## Application for EPE for an Order Granting Development Consent

### Traffic and Access Impacts, Local Highways and Site Visit Adequacy

This submission raises concerns regarding the robustness of the Applicant's assessment of construction traffic associated with Site B, particularly in relation to access points SA03–SA06 on Great Staughton Road. It also highlights the interaction with existing agricultural use of this route and the importance of the Examining Authority's site visit in fully understanding both highway constraints and the wider landscape context. It also raises concerns about the limited site visit to Hoo Farm.

Status
DCO Application

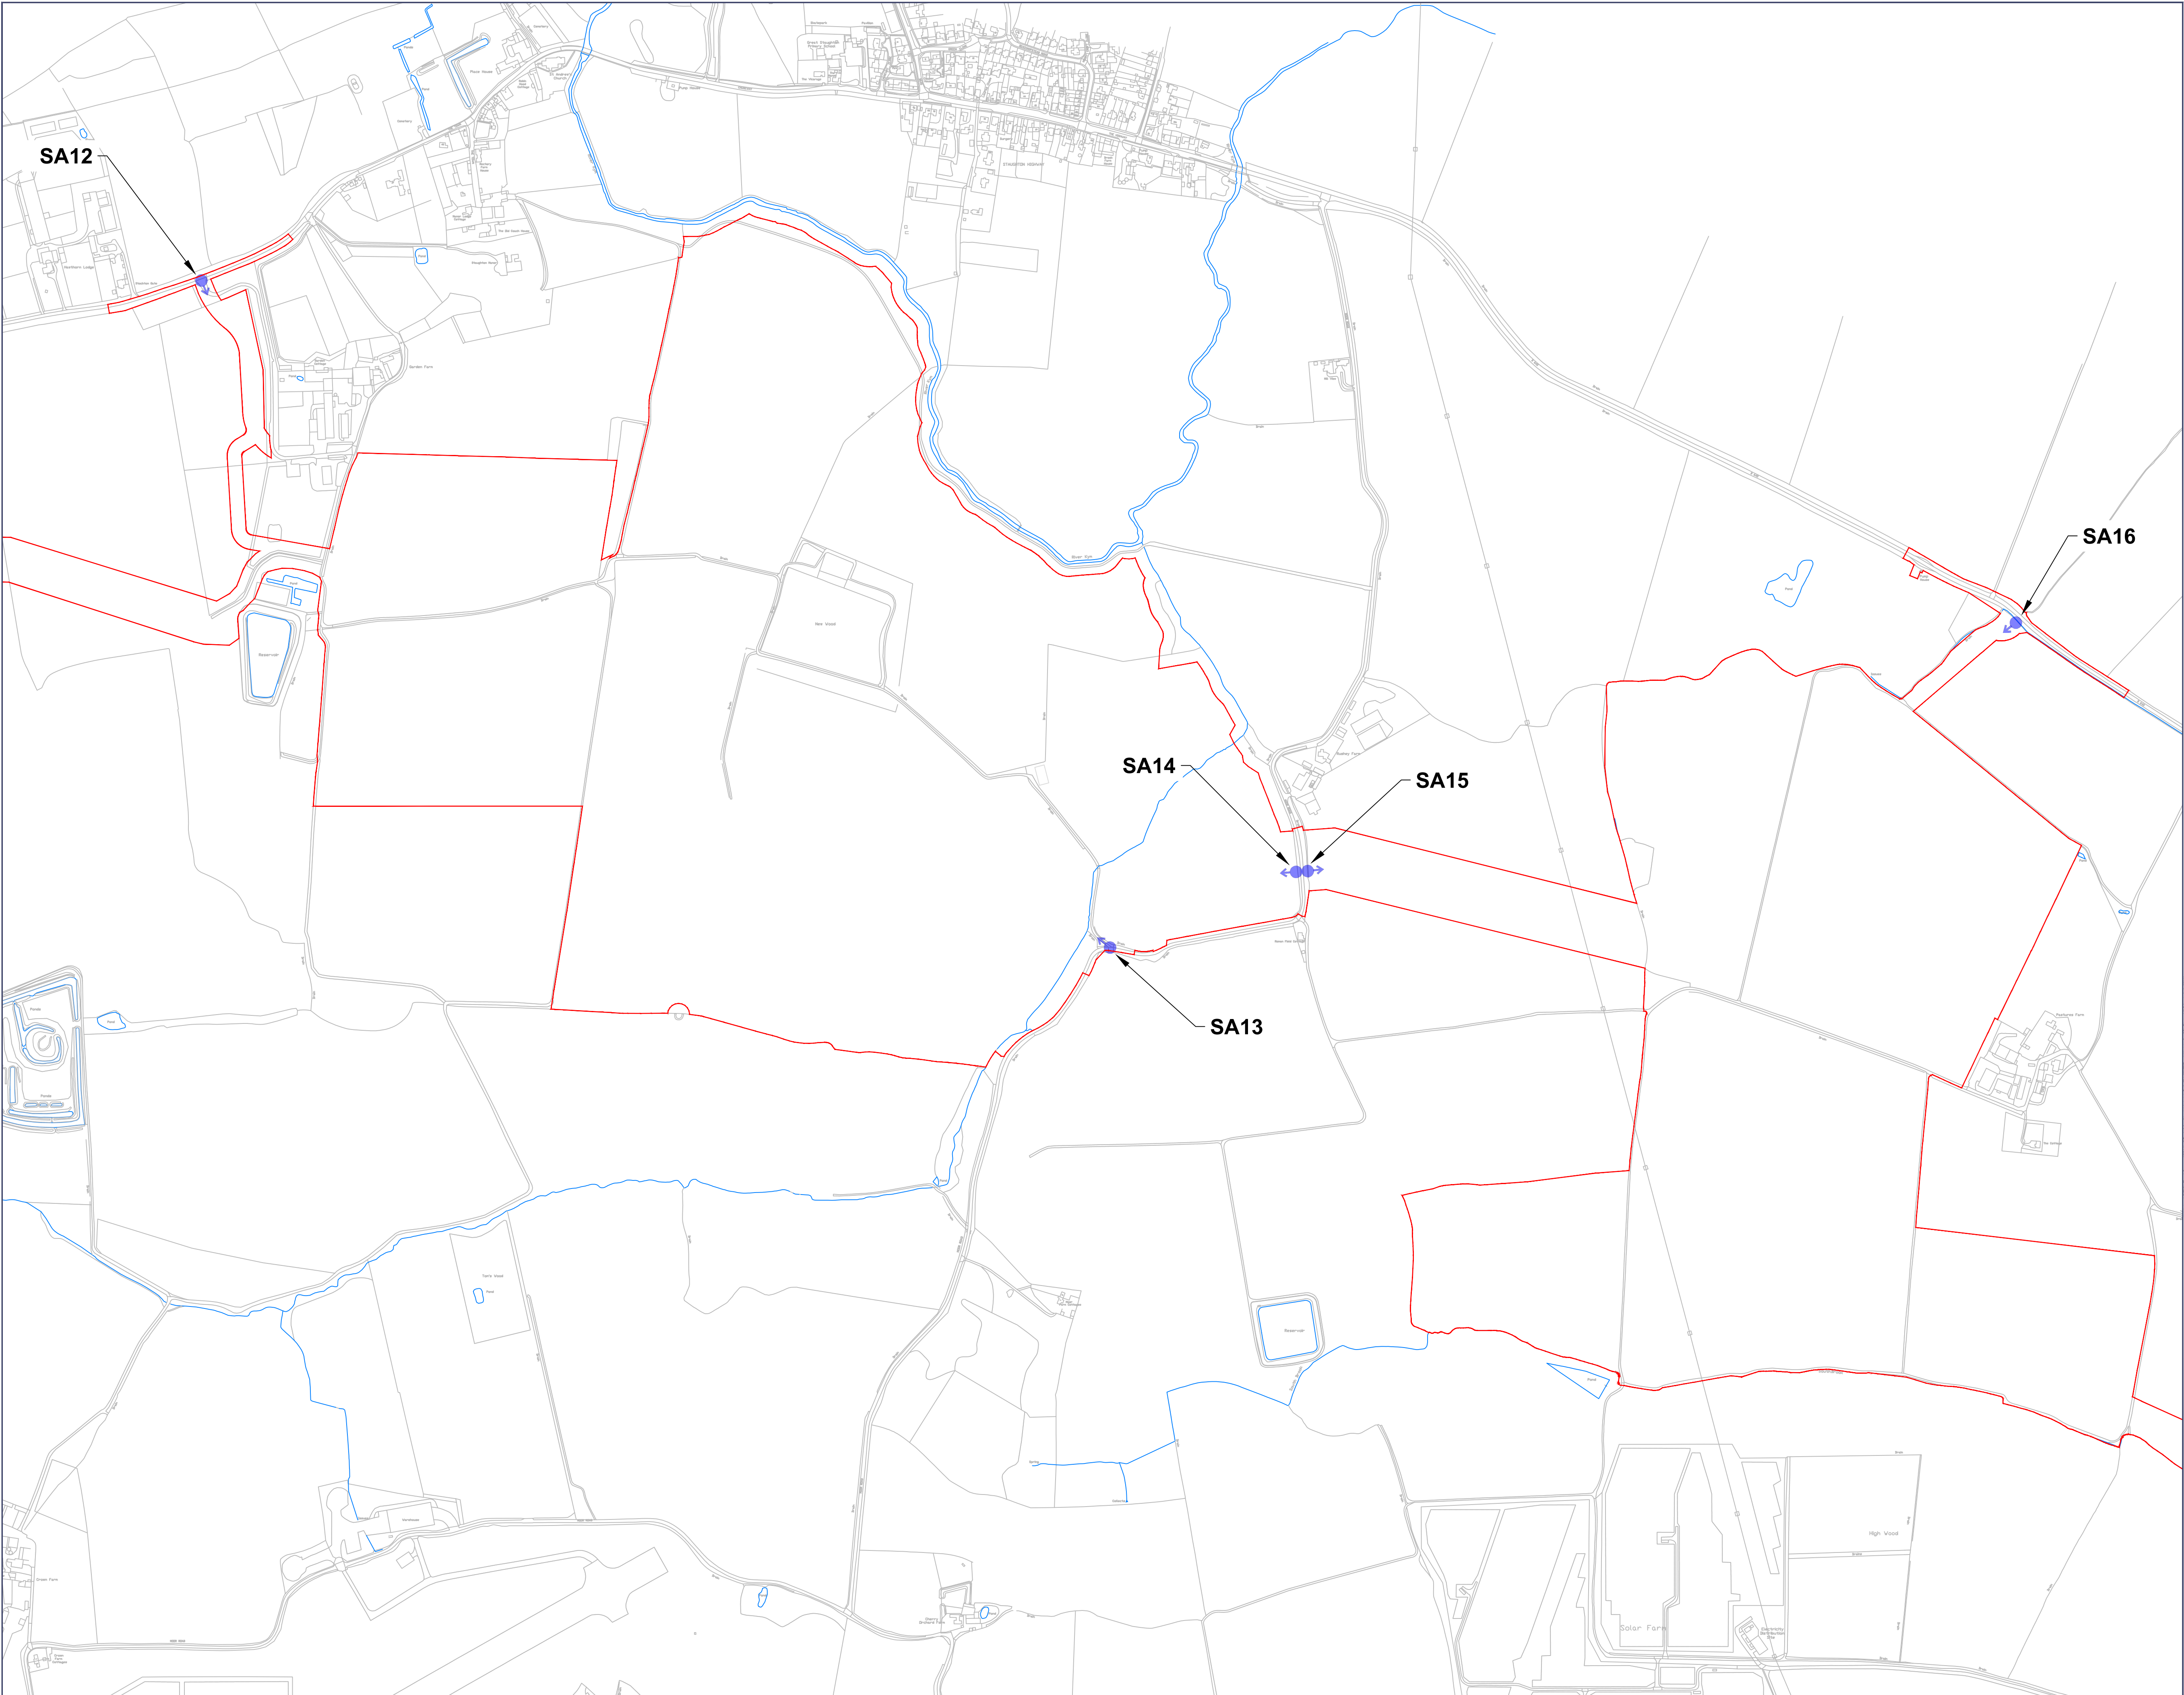
The Applicant's Outline Construction Management Plan (Sections 5.1.8 and 5.2.1–5.2.2) identifies multiple access points serving Site B from Great Staughton Road (SA03, SA04, SA05 and SA06), including the upgrading of existing field gate accesses to accommodate construction traffic.

However, the accompanying traffic-flow information appears to assign only minimal construction vehicle movements to these access points, despite the scale of development proposed.

- SA03 serves approximately 4 hectares
- SA04 serves approximately 6.25 hectares
- SA06 serves approximately 20 hectares

The application does not explain how these areas can be constructed with such limited access movements. For clarity, a detailed breakdown of construction traffic by access point and activity type (including HGVs, deliveries, staff vehicles and plant) is required, rather than aggregated site-wide totals.

- Break down construction logistics by access point
- Explain delivery volumes or frequency
- Clarify workforce access arrangements
- Identify plant and machinery movements
- Set out any internal haul or distribution strategy

1. Require a detailed breakdown of construction traffic by access point (SA03–SA06) and activity type

Figure 1: Applicant's Proposed Itinerary for the Accompanied Site Inspection

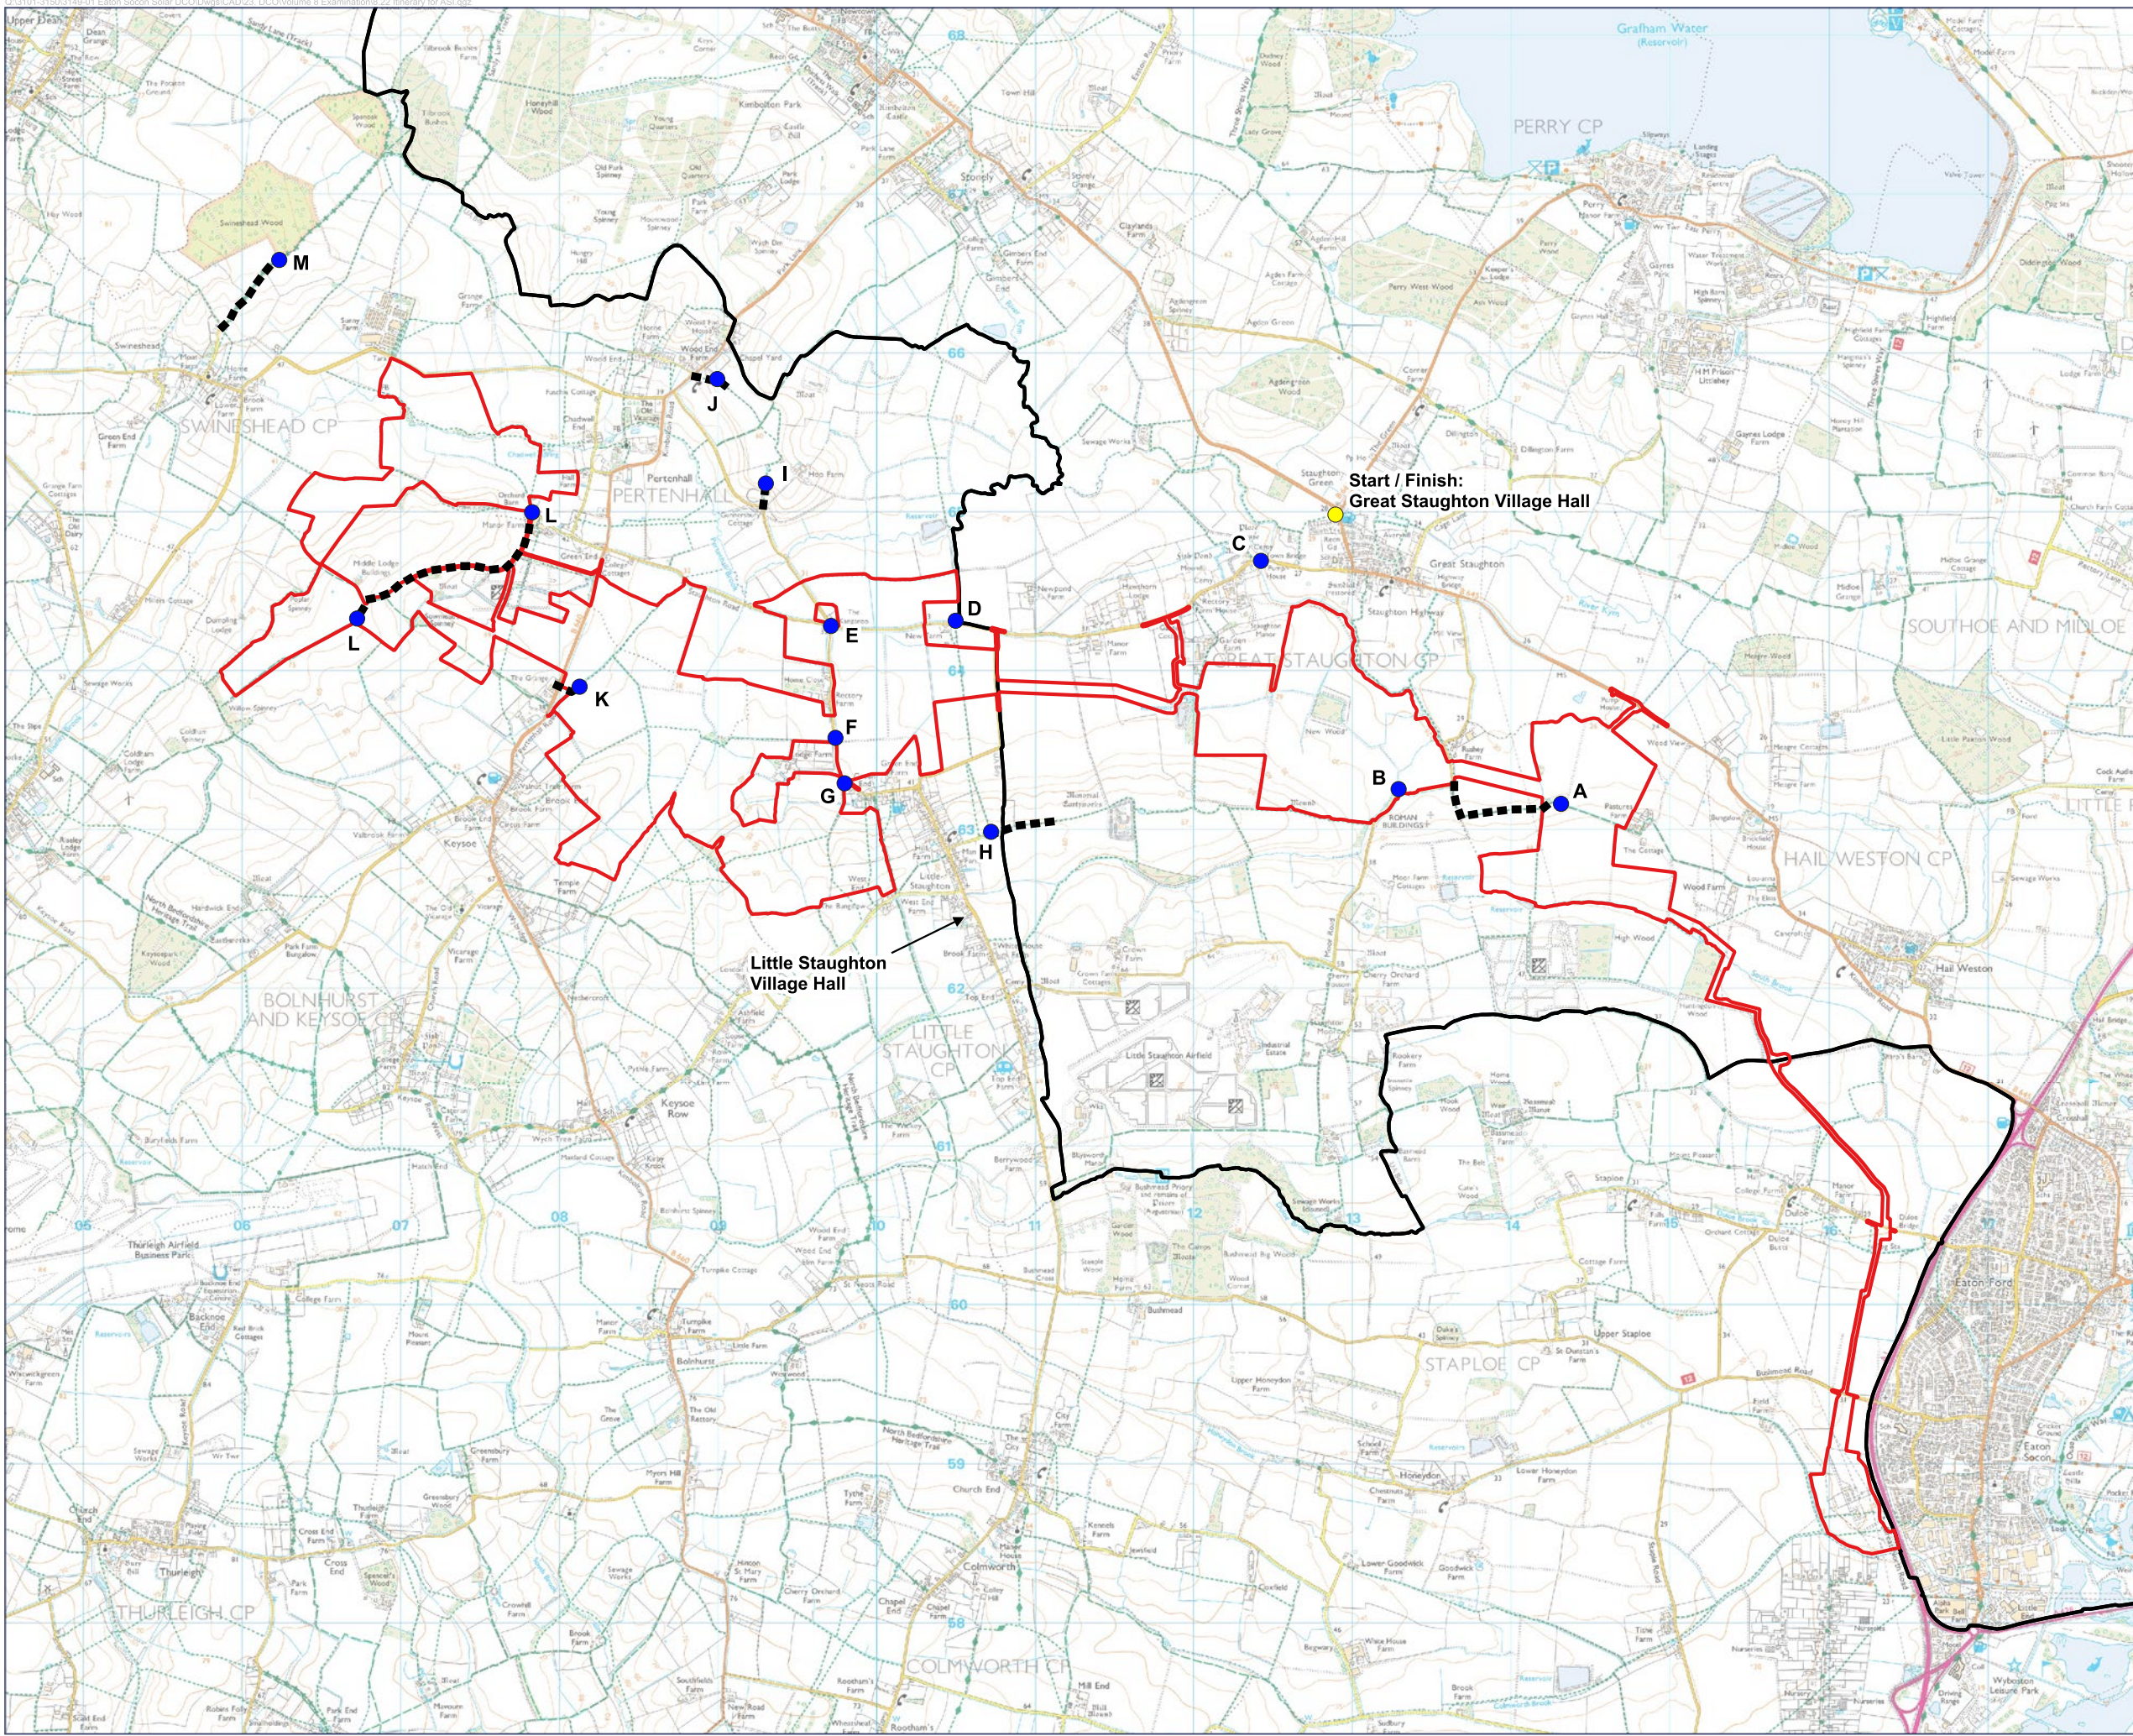
This creates uncertainty as to whether construction traffic on Great Staughton Road has been materially underestimated. Within the Applicant's Draft Site Visit Itinerary the section intended to cover the section Gt Staughton Rd is describe as a 'drive through'. Given the number of proposed access points, the narrow rural nature of the road and the concerns regarding construction traffic interaction, this is not adequate. It does not allow appreciation of:

- Road width and passing constraints
- The relationship between Access Points SA03-SA06 and the road
- Interaction between HGVs and large agricultural vehicles

The proposed site visit stop at Hoo Farm is particularly important in understanding both highway constraints and the wider landscape context of Site A and B. I welcome that the Examining Authority is already due to visit the public footpath at Hoo Farm, as requested by SEPE, to experience selected LVIA viewpoints and views of surrounding settlements and landscape features. While useful, this stop is necessarily limited in scope and reflects only specific LVIA receptor locations. It is therefore respectfully requested that a short additional stop is made at the elevated viewpoint on land at the top of the hill at Hoo Farm (with landowner permission). From this location there is a true panoramic view of the wider landscape, including:

2. Seek clarification of construction logistics and vehicle assumptions for Site B
3. Consider the interaction between construction traffic and agricultural vehicle movements on the Great Staughton Rd.
4. Include a short additional stop at the elevated Hoo Farm viewpoint to fully understand the highway constraints, landscape and floodplain context and the relationship between Site A and B settlements and the road network.
